Change of use and extension to create 3no. self contained apartments and 1no. maisonette. This application affects the character and appearance of Arundel Conservation Area
Arden Guest House 4 Queens Lane Arundel

Thank you for your internet representation made on 1st May 2014 which has been recorded as '**support**' with the comments as follows:

1:500 Block Plan

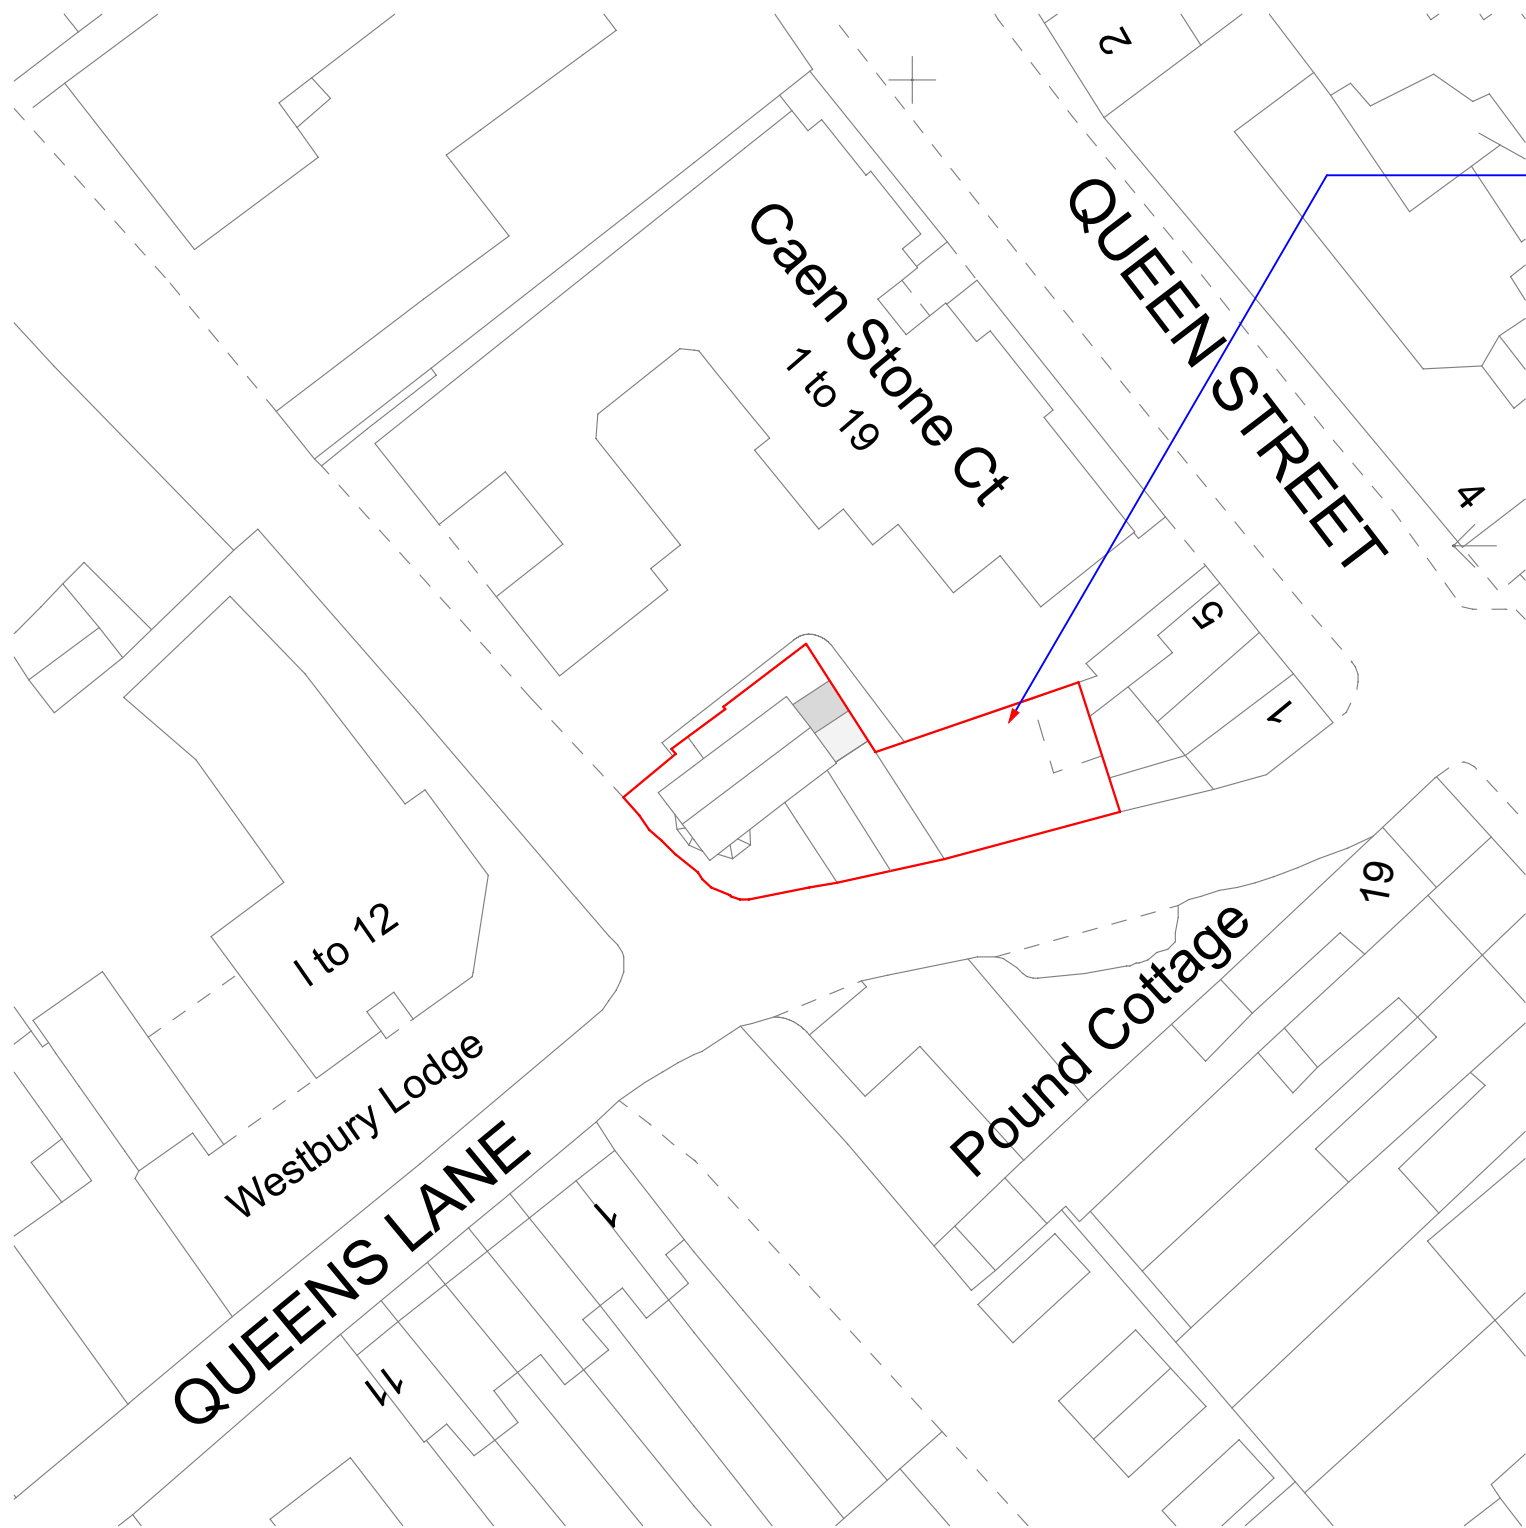
The site plans indicates an existing concrete panel garage be removed. Should the building incorporate asbestos then we insist residents of Caen Stone Court be notified prior to demolition taking place.

The location of the planned parking bay for flat 2 at the junction of Queens Lane and Fitzroy Road is hazardous especially taking into account the road width. We believe parking for this flat should be relocated to the visitors bay especially as there is adequate public parking available in the Lido car park.

Job Title	Arden Guest House		
Client	Mr & Mrs Meathrel		
Drawing Name	Proposed Elevations		
Drawing Status	Planning		
Drawn by	DF	Date	Dec 13
Checked by		Date	
Drawing Scale	1:100 at A2		
Drawing No	Status	Revision	
13519/	08

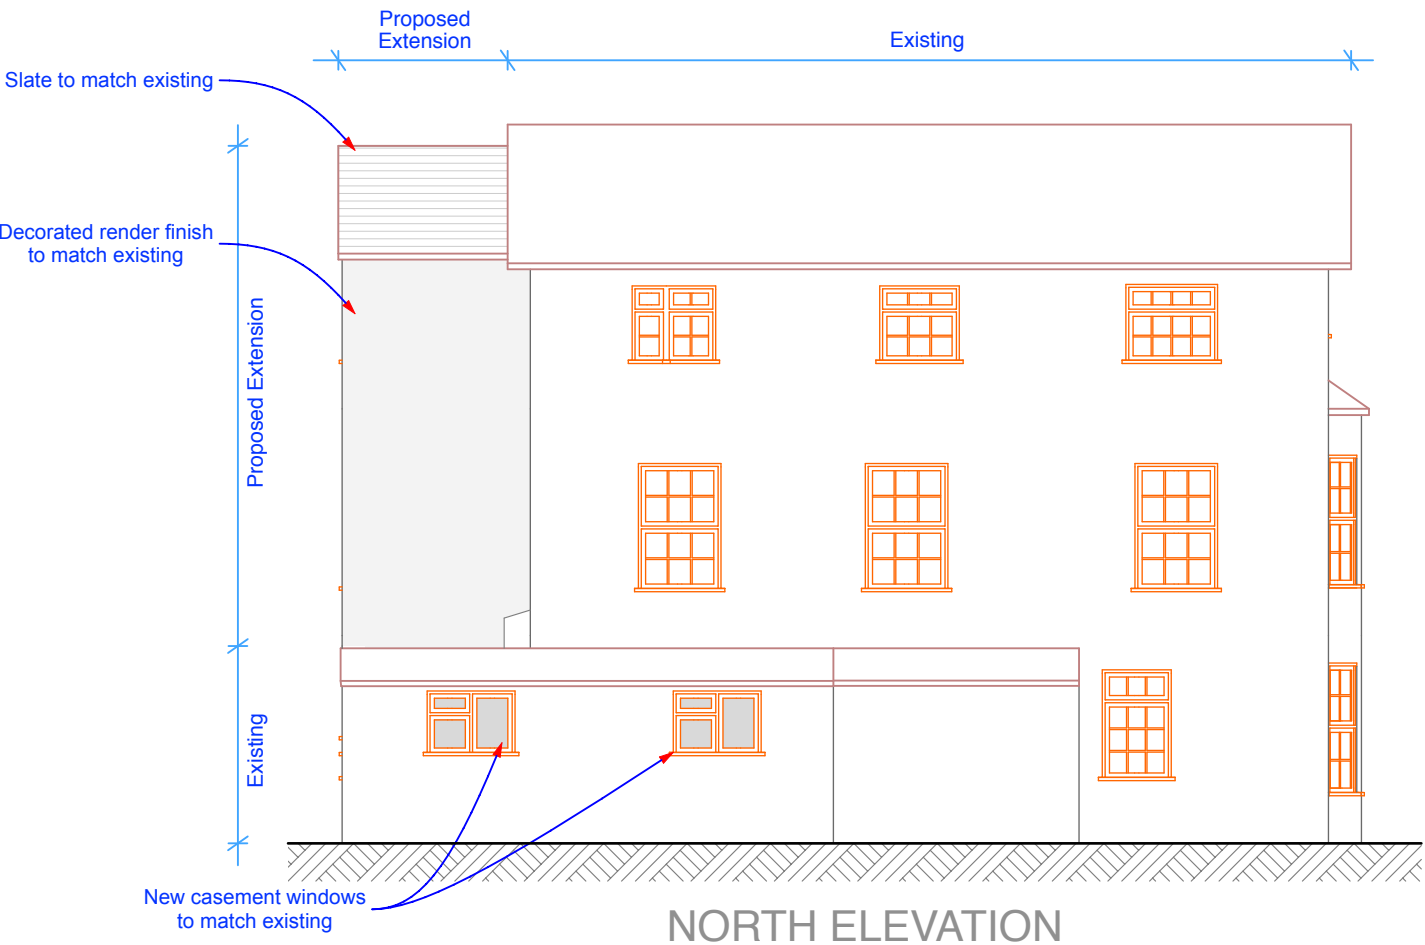
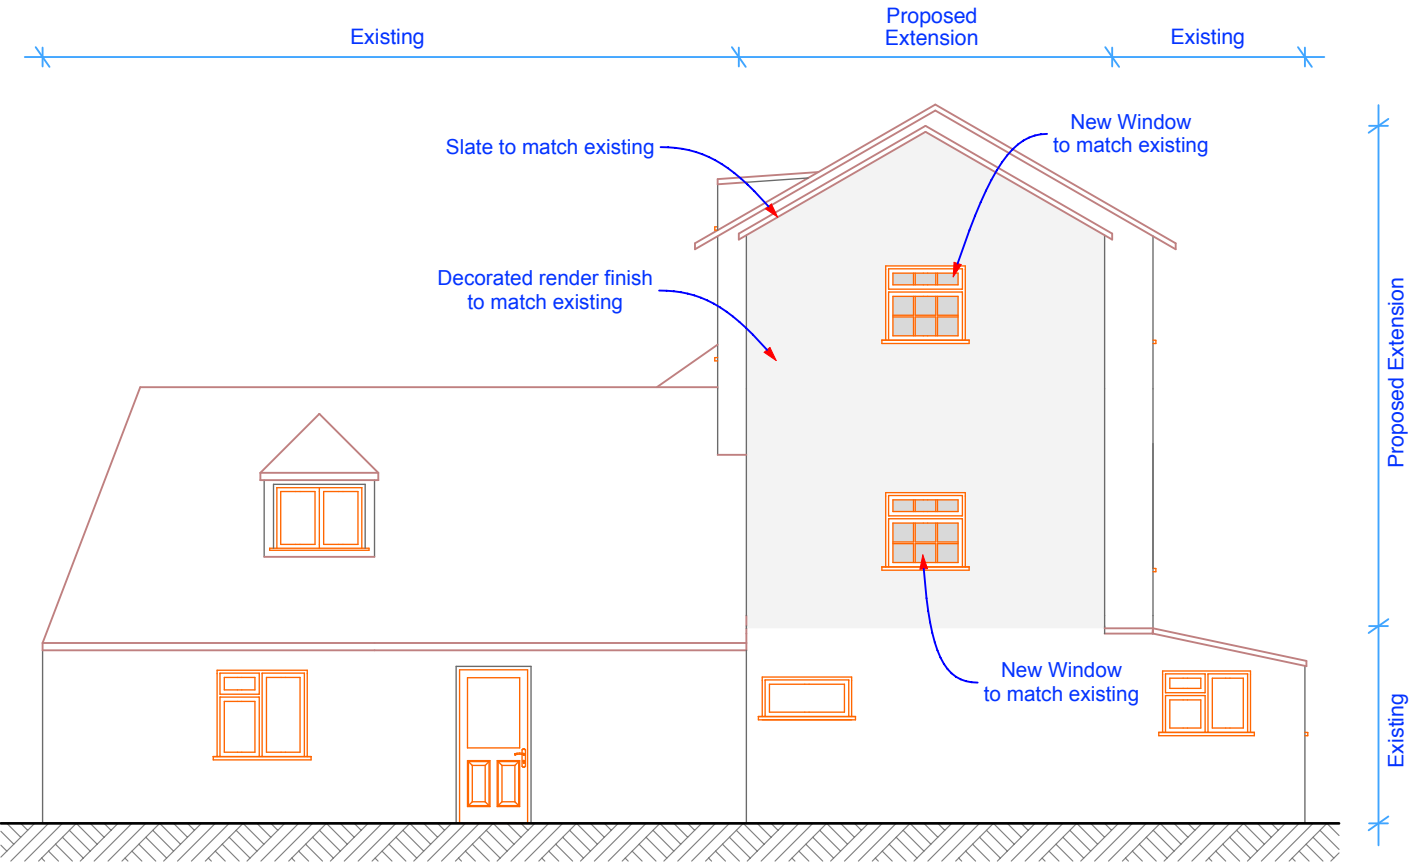
Our property directly faces the East elevation and we are concerned with privacy. Windows in the new staircase will have an effect on this and we insist they are fitted with obscure glass.
